Please ask for: Sian Eggington
Email: sian.eggington@terraquest.co.uk
Telephone: 0121 2341390
Our Ref: R/154/20/HH
Your Ref:
Date: 20th August 2020

Application for Planning Permission for Works or Extension to a Dwelling

Development: (Revised application from R/84/20/HH)
Single storey part front, part side garage extension.
Part conversion of existing garage to form utility, WC, Kitchen, Dining area.
Formation of new flat roof over new extension and pitched roof over part of existing garage.
Installation of 1 no. roof lights in existing flat roof and 1 no. roof light in pitched roof
Insulate and externally render new and existing walls to single storey building.

Location: 23 Mill Lane Rustington BN16 3ED

EXISTING
23 MILL LANE
RUSTINGTON
SCALE 1:200; 1:100 DRG 3

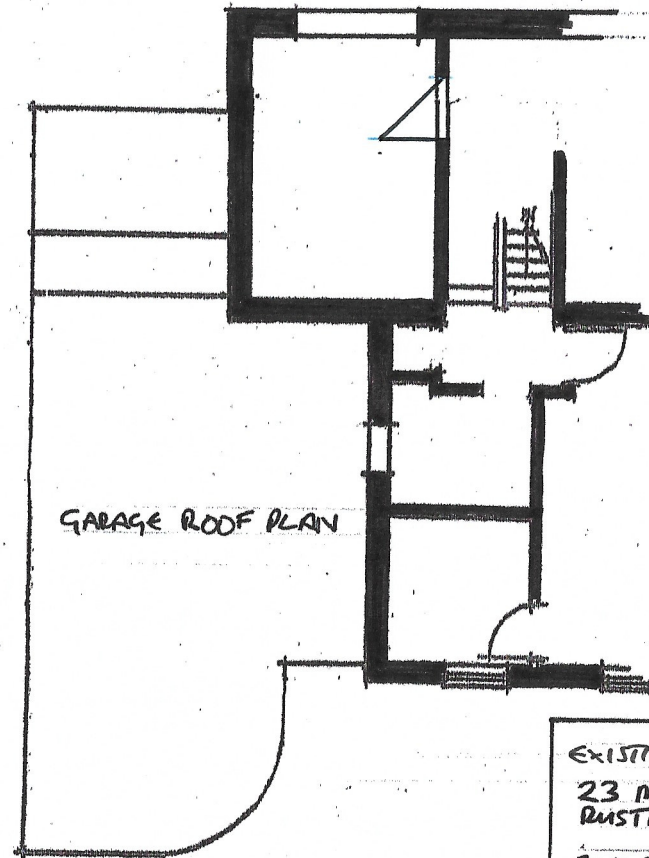
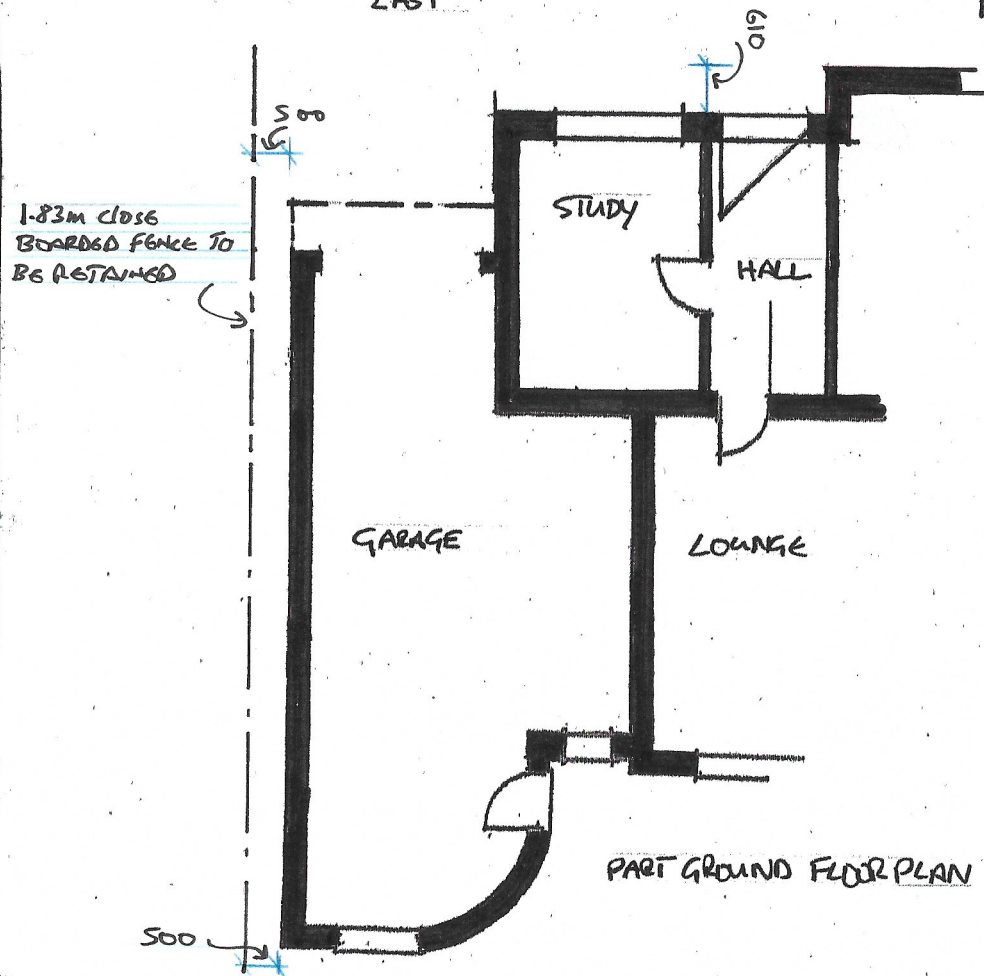
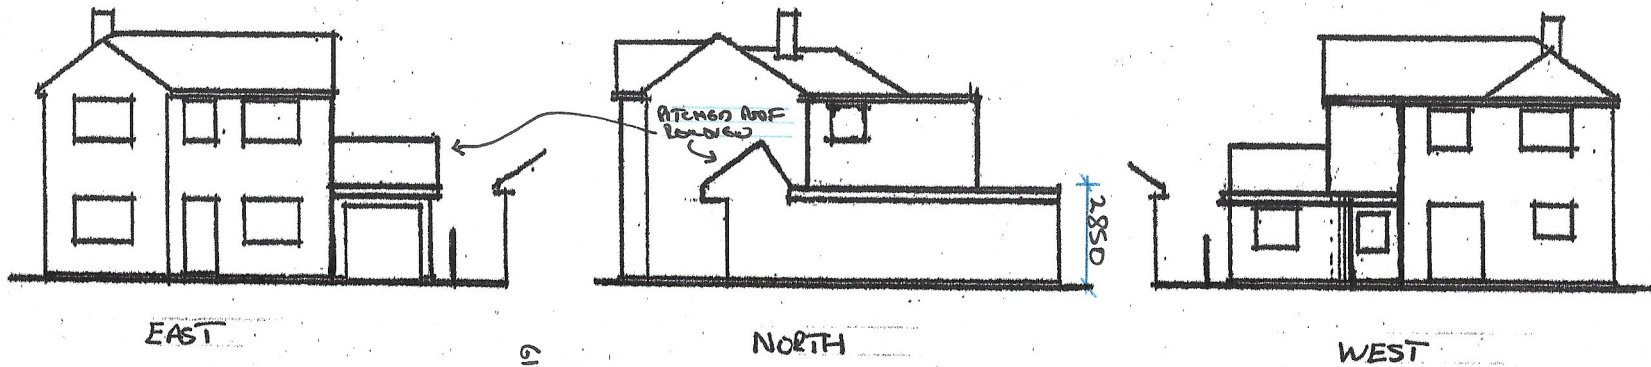
Scale: The plans are not measuring to scale due to incorrect paper size. Please amend.

BLOCK PLAN

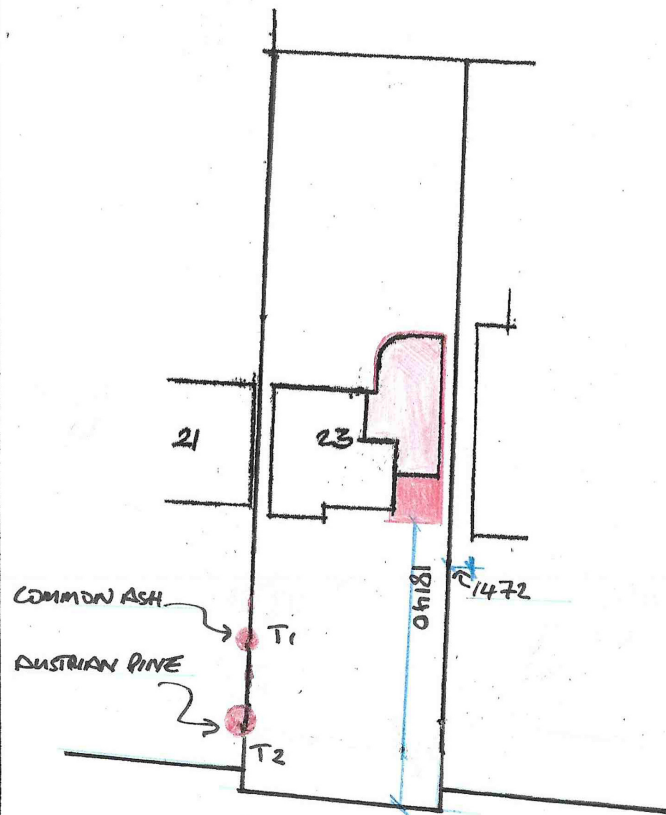
Block Plan

Please submit 1 electronic or 3 paper copies of a block plan at a scale of 1:500. Further details of what must be included on the plan can be found in the Validation Requirements List. Please note this must include the proposed extension with dimensions to all site boundaries
